From: Simon Davis <Simon.Davis@arun.gov.uk>
Sent: 18 September 2020 14:52
To: Planning.Responses <Planning.Responses@arun.gov.uk>
Subject: FW: AL/64/20 - Springfield Hook Lane Aldingbourne

From: Emma Avis [REDACTED]
Sent: 18 September 2020 14:47
To: Simon Davis <Simon.Davis@arun.gov.uk>
Subject: AL/64/20 - Springfield Hook Lane Aldingbourne

I've just been reviewing the revised site layout, drawing no: 1186/DP04 Rev 01. In general the LHA would raise no concerns and the previously proposed conditions should still stand (under AL/27/20). I have noticed though that the dedicated turning head has been lost somewhat in the design and now also accommodates visitor parking spaces. The applicant needs to provide some tracking of a refuse vehicle to demonstrate that a collection vehicle can turn fully on site and enter the highway in forward gear. Also that any parking arrangements will not hinder this movement.

SWEPT PATH ANALYSIS
LARGE REFUSE TURNING ON SITE

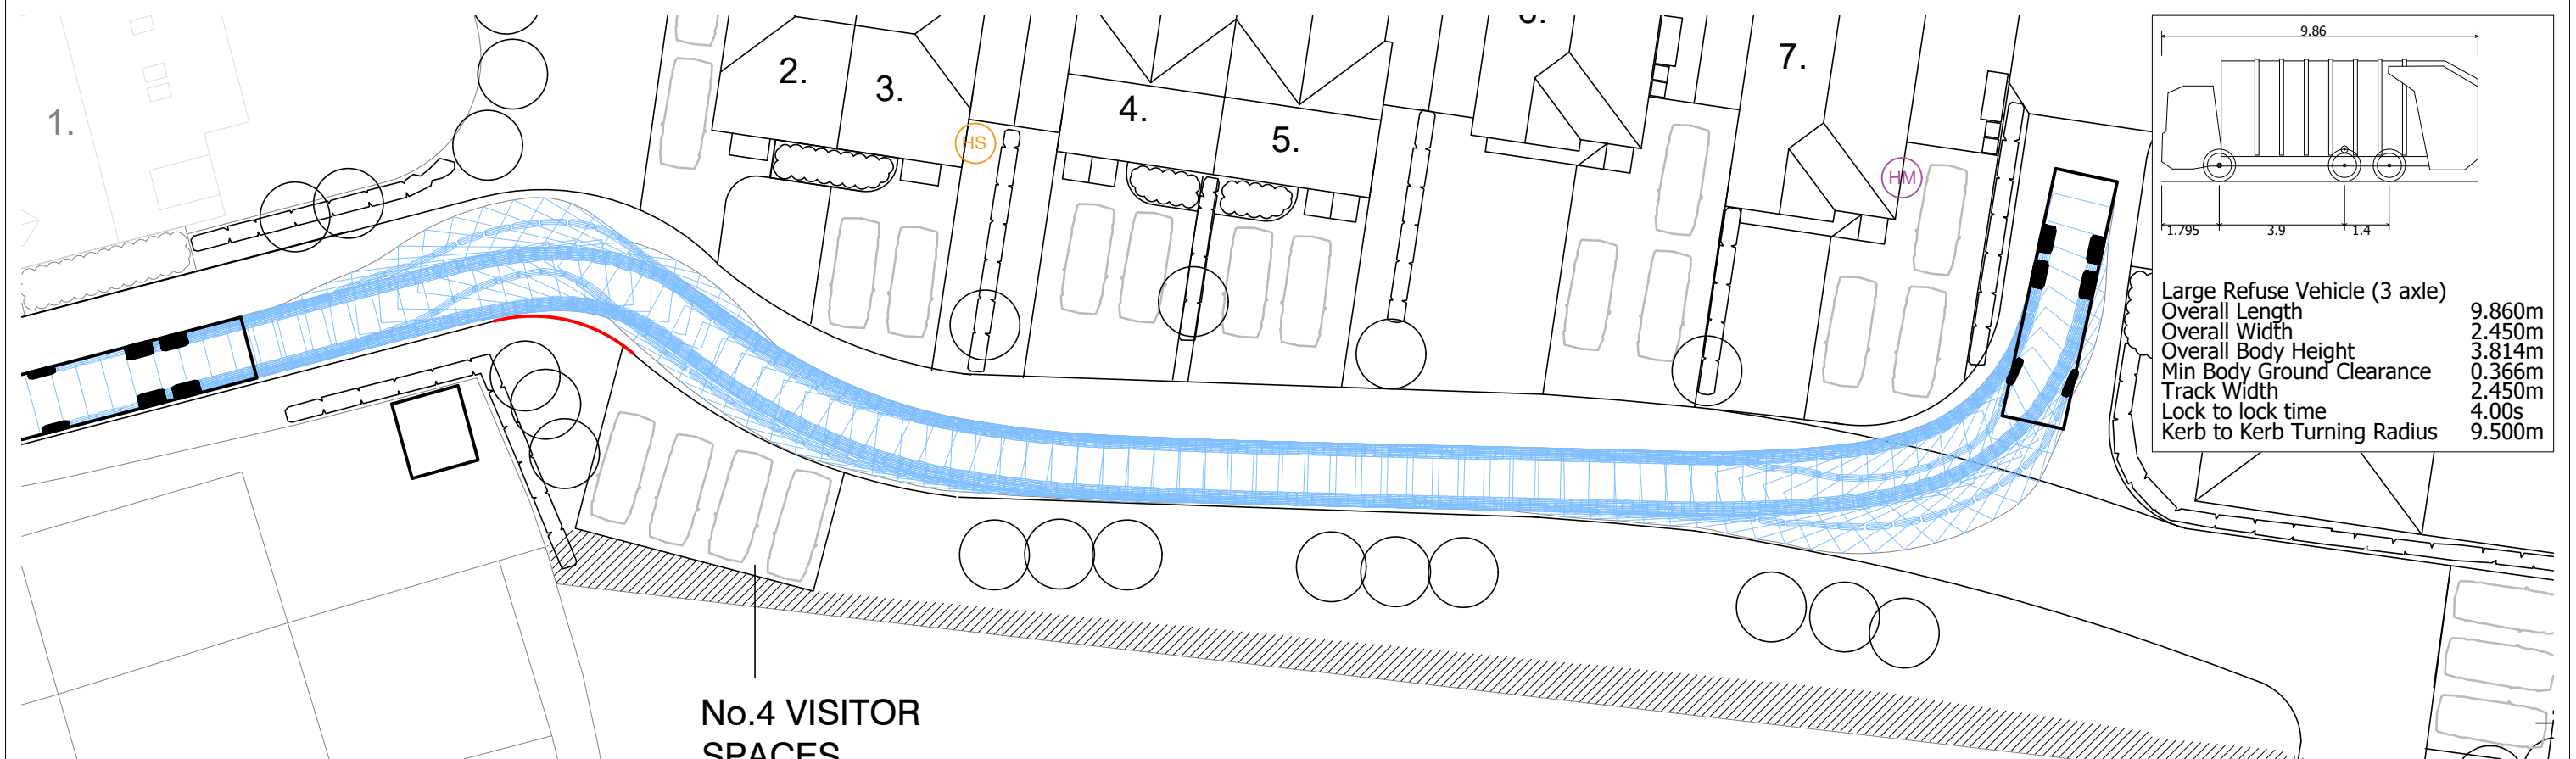
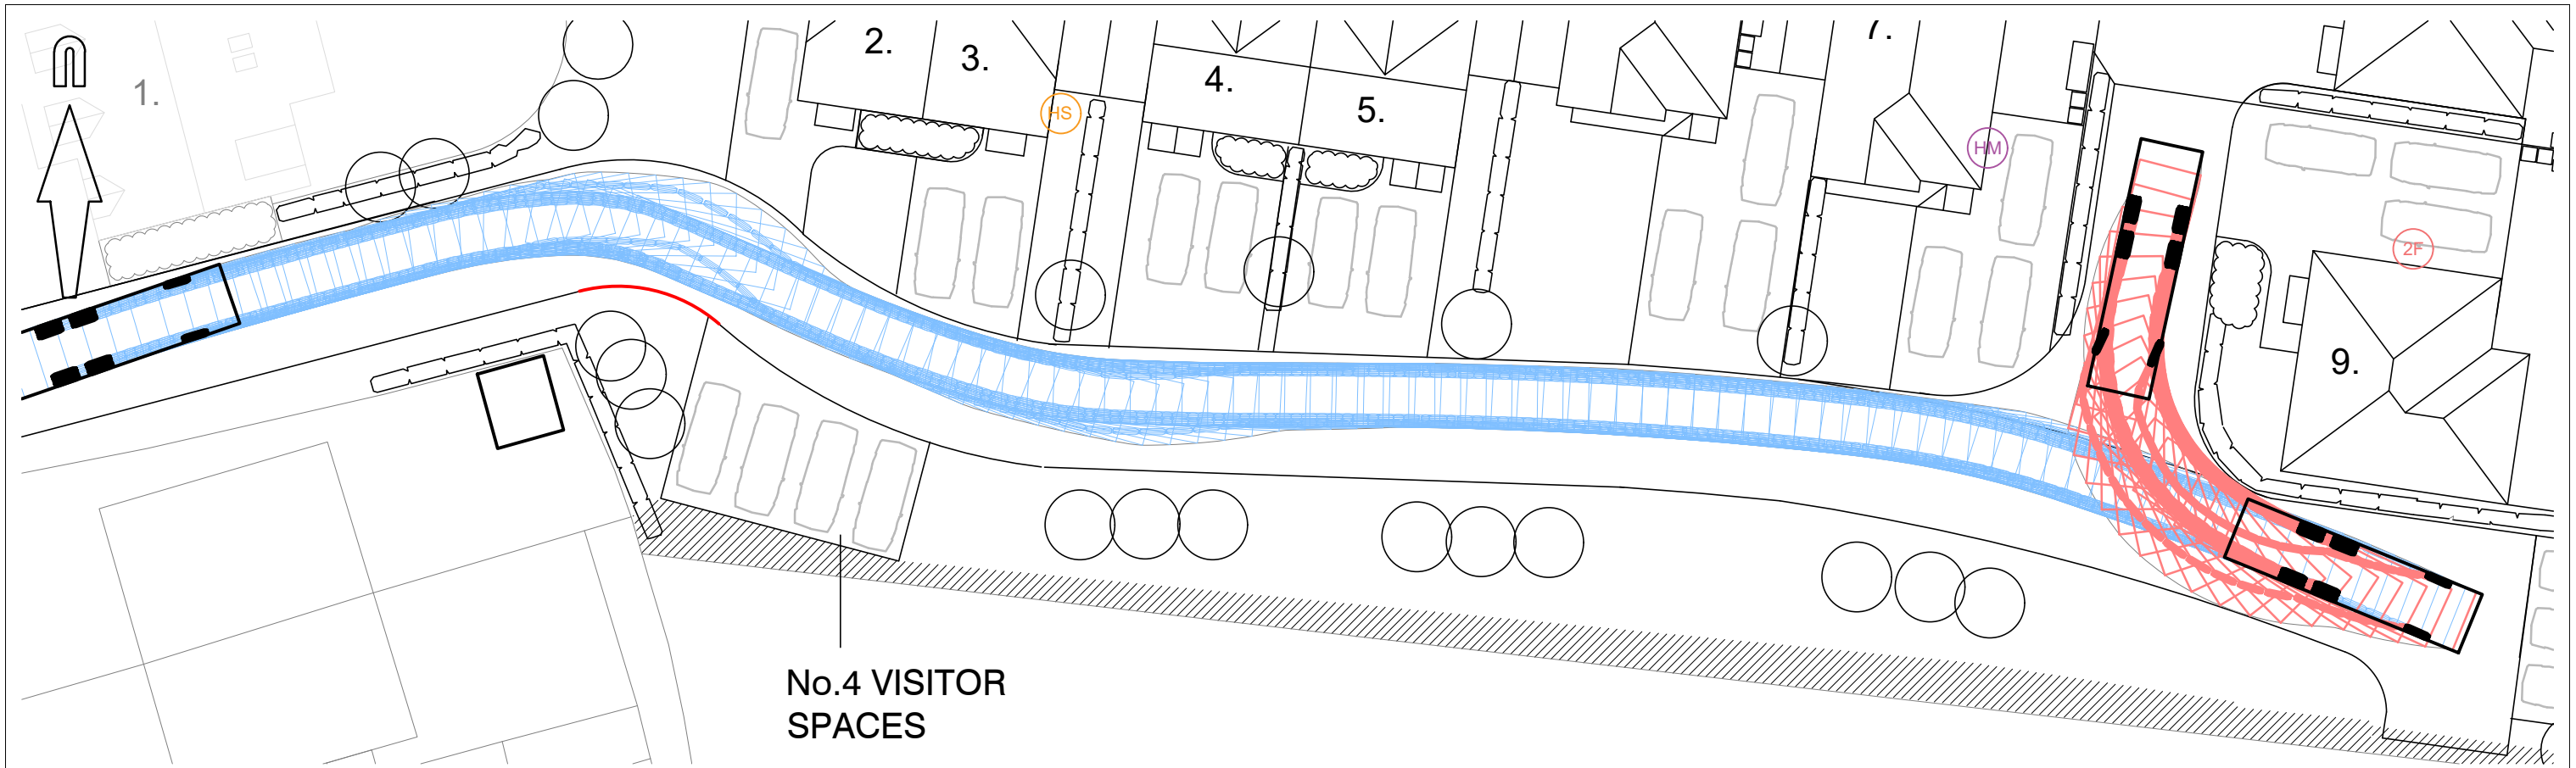
Please re-consult once this detail has been received.
